# **SCOPING OPINION:**

## **Proposed Shepway Energy Park**

**Case Reference: EN0110017**

**10 July 2025**

Figure 9-1: Zone of Theoretical Visibility

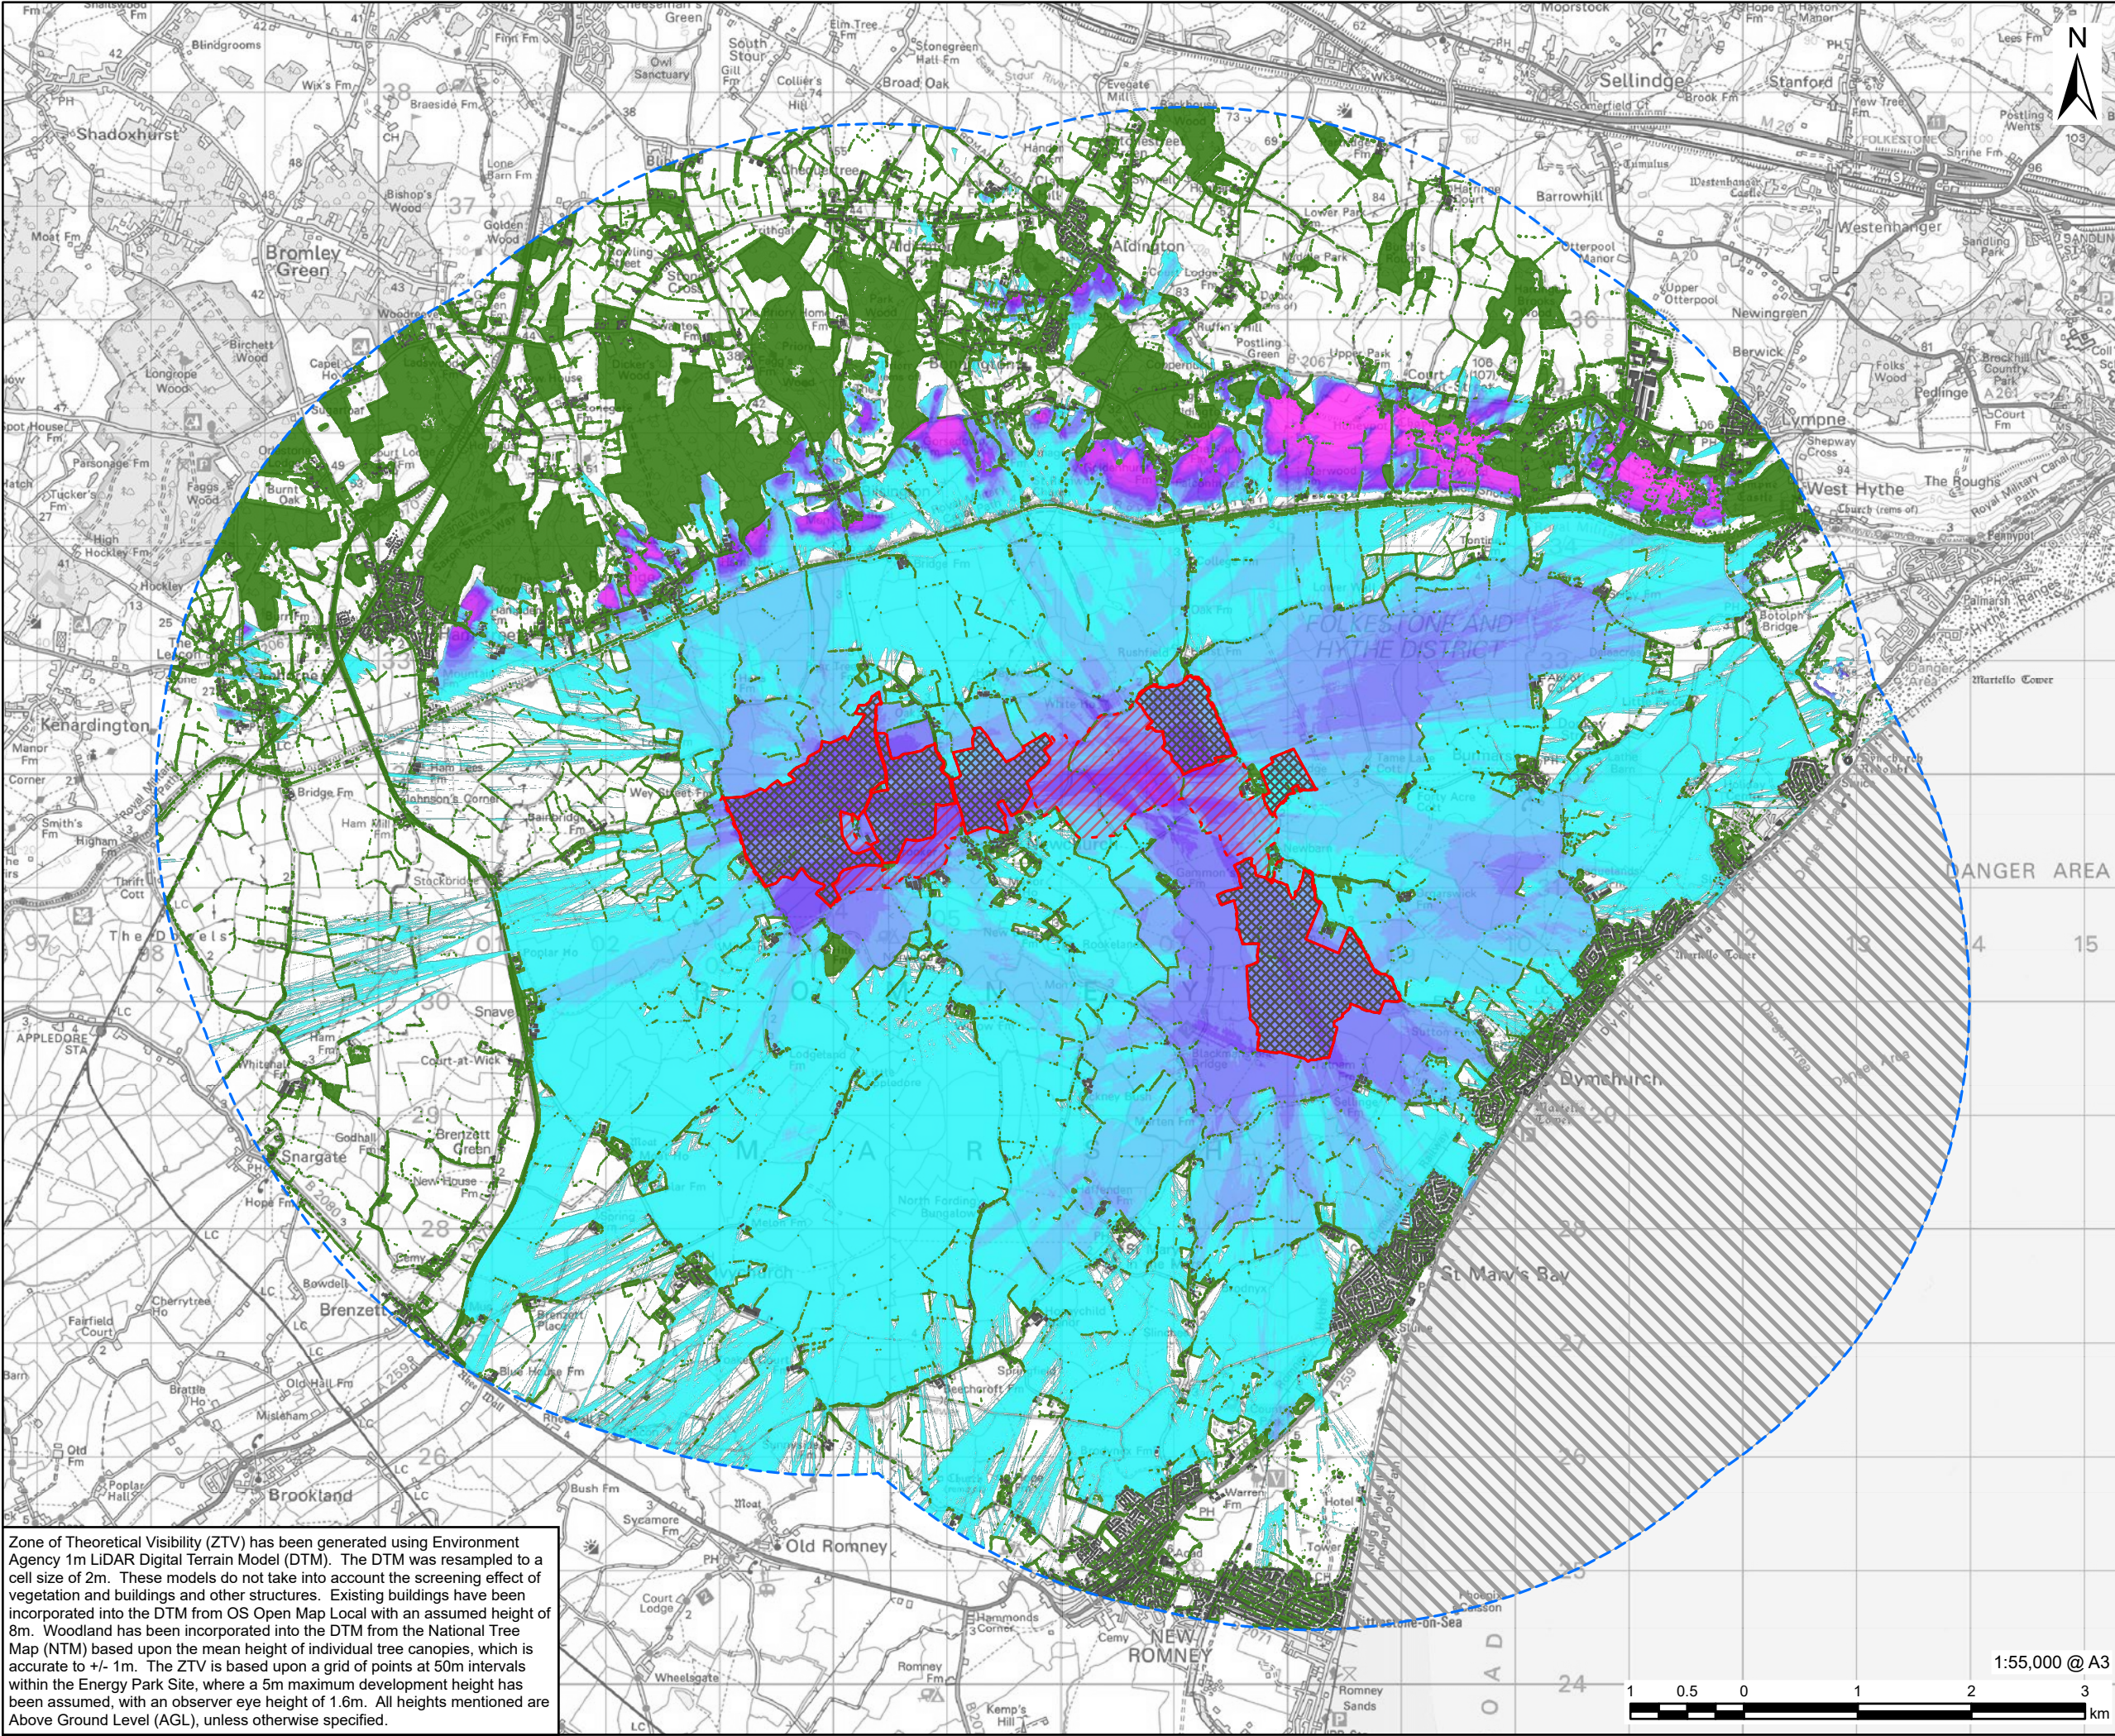
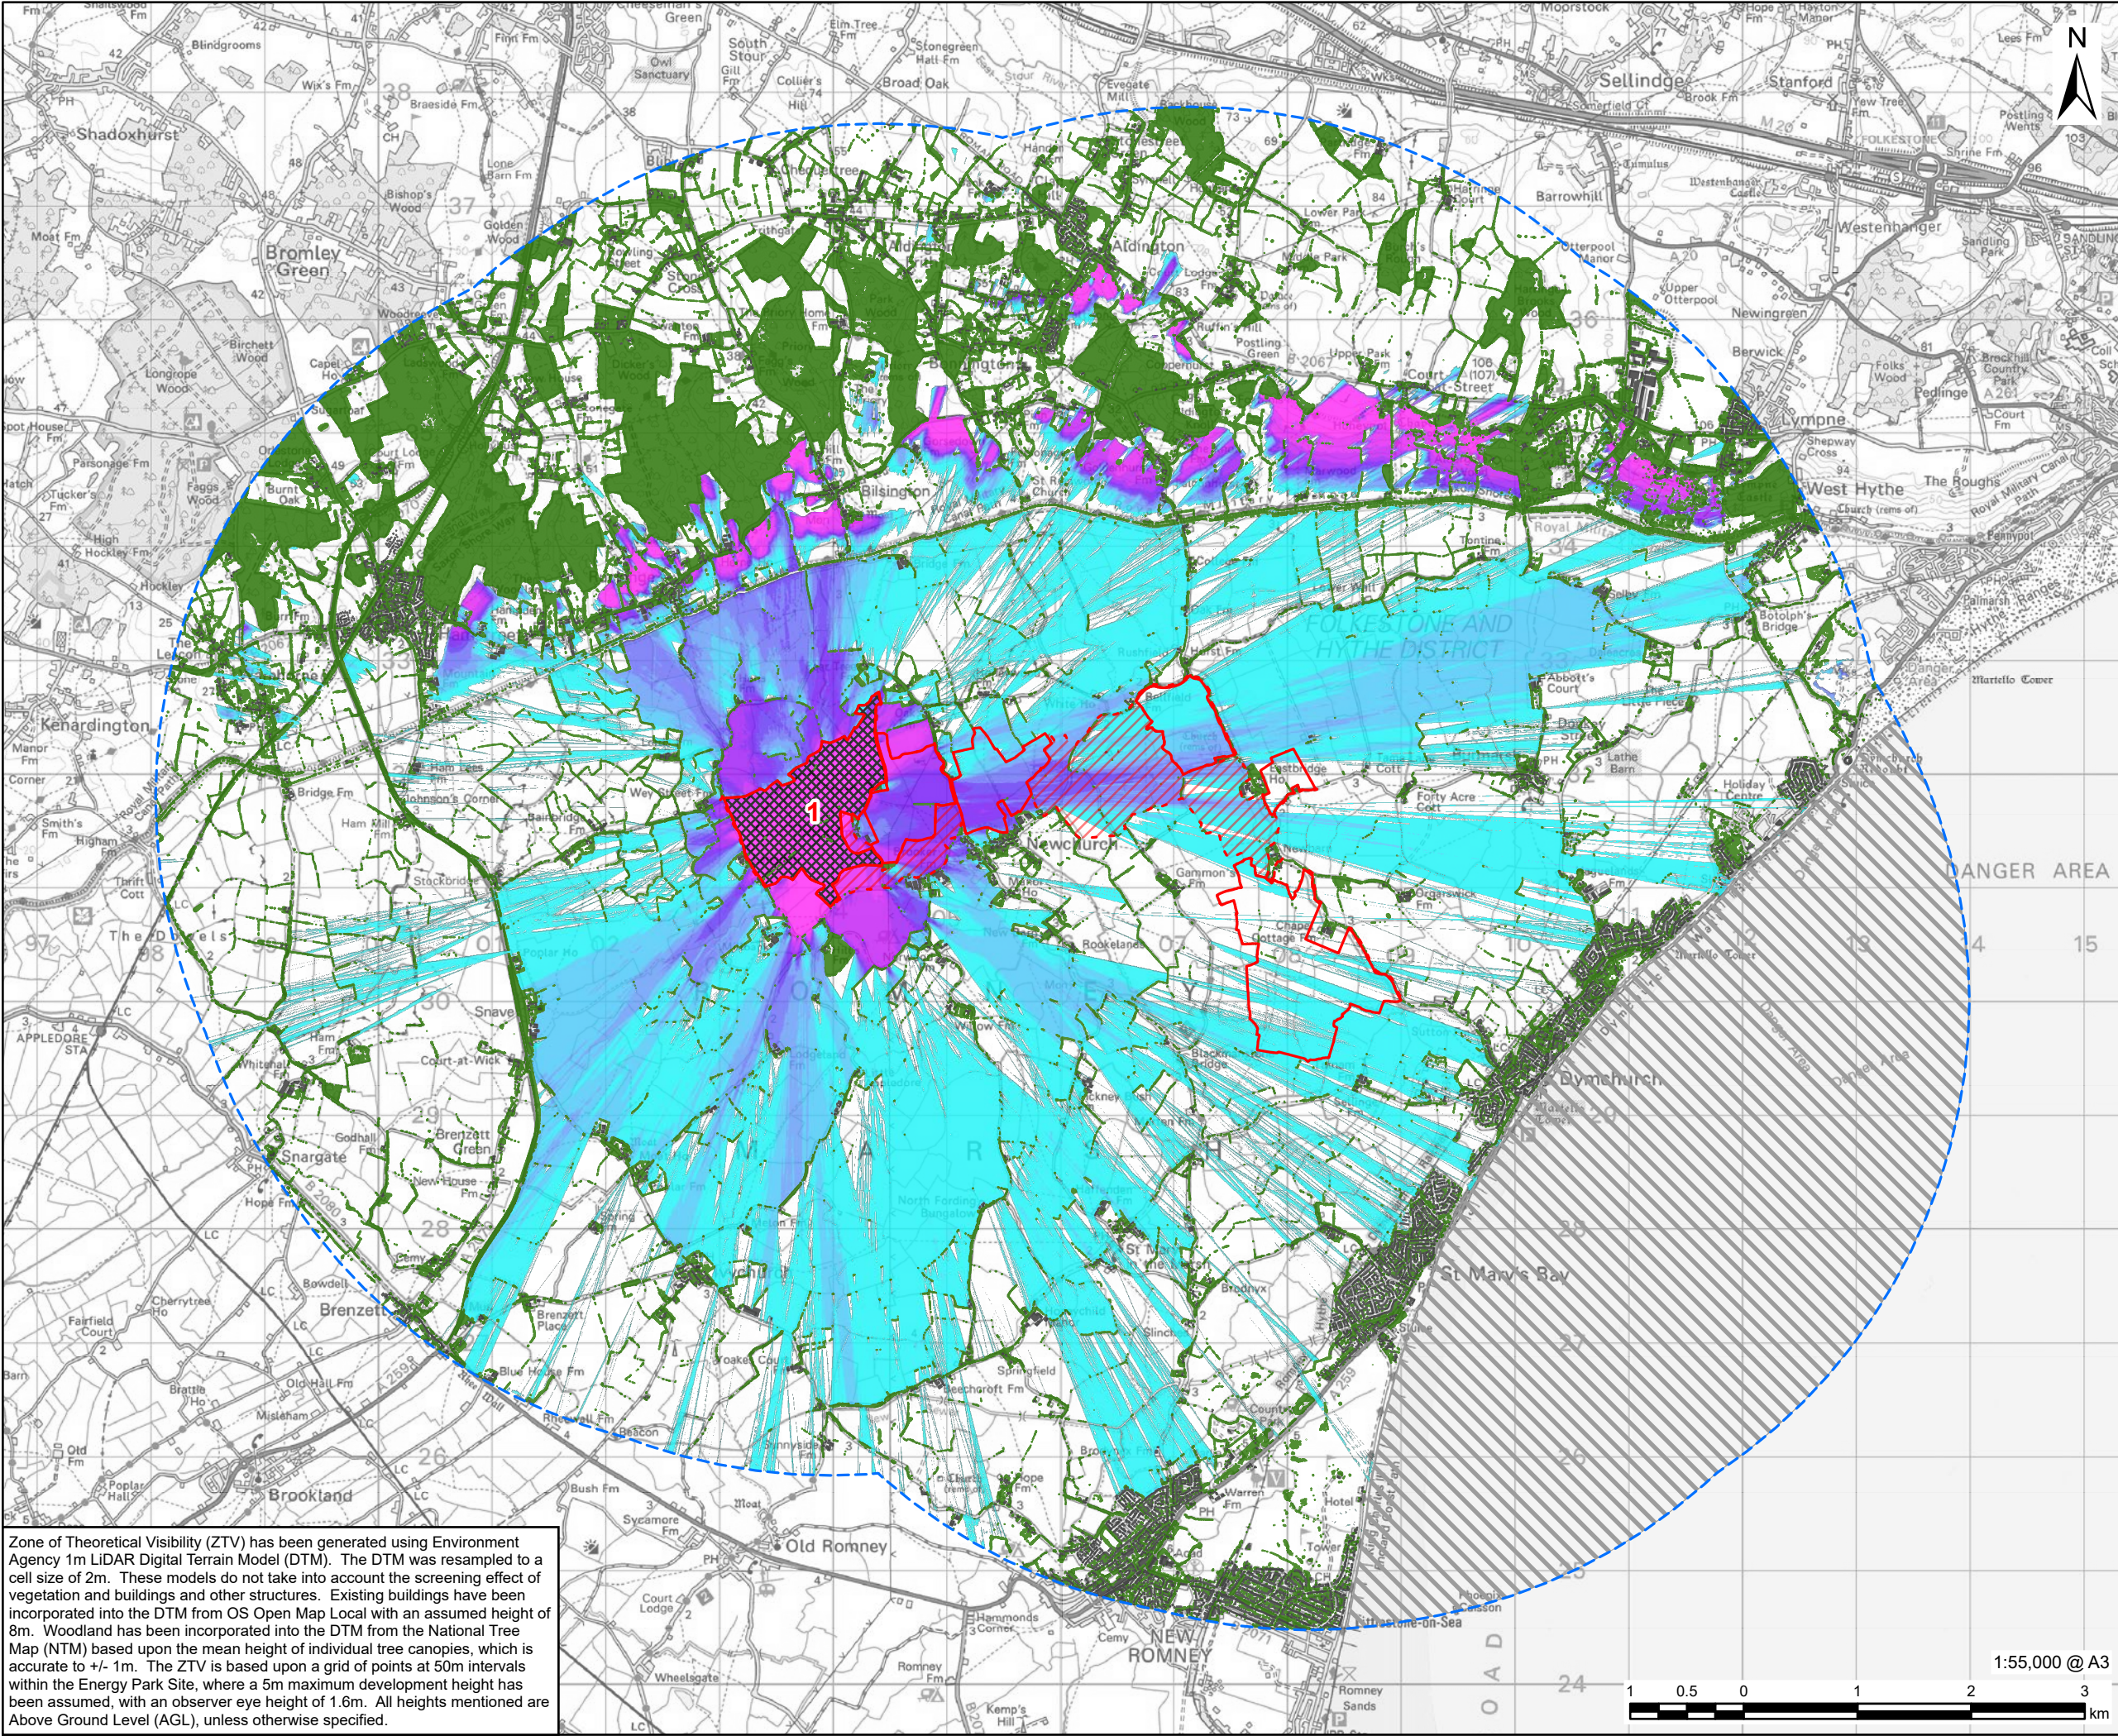
ID	Ref	Description	Inspectorate's comments
333	Paragraphs 9.2.1 -9.2.10 Figures 9.1a-h	Study area – Zones of Theoretical Visibility (ZTV)	<p>The Scoping Report states that a 5km LVIA study area is considered appropriate for the Energy Park Site although the extent of the full LVIA study area is to be reviewed throughout the iterative design process, subsequent ZTV production and further fieldwork.</p> <p>The Inspectorate considers that the study area should be informed by the extent of likely effects rather than an arbitrary study area boundary.</p> <p>The ES should justify the extent of the study area with reference to recognised professional guidance and the extent of the likely impacts, informed by fieldwork and relevant models or approaches such as the ZTV.</p>
334	Paragraph 9.2.7	LVIA Study Area for the Interconnecting Cable Corridors and the Grid Connection Route	<p>The Scoping Report states that the LVIA study area for the interconnecting cable corridors and the grid connection route would reflect the temporary nature of impacts likely to arise for these elements, with no permanent above-ground structures, and the Applicant does not anticipate that ZTVs would be provided for these elements and the study area, which would be refined once the extents are defined, will be proportionate to the expected effects.</p> <p>The Inspectorate considers that the ES should evidence how the study area has been derived to ensure it is representative of the project's effects and should be agreed with relevant consultation bodies where possible.</p>
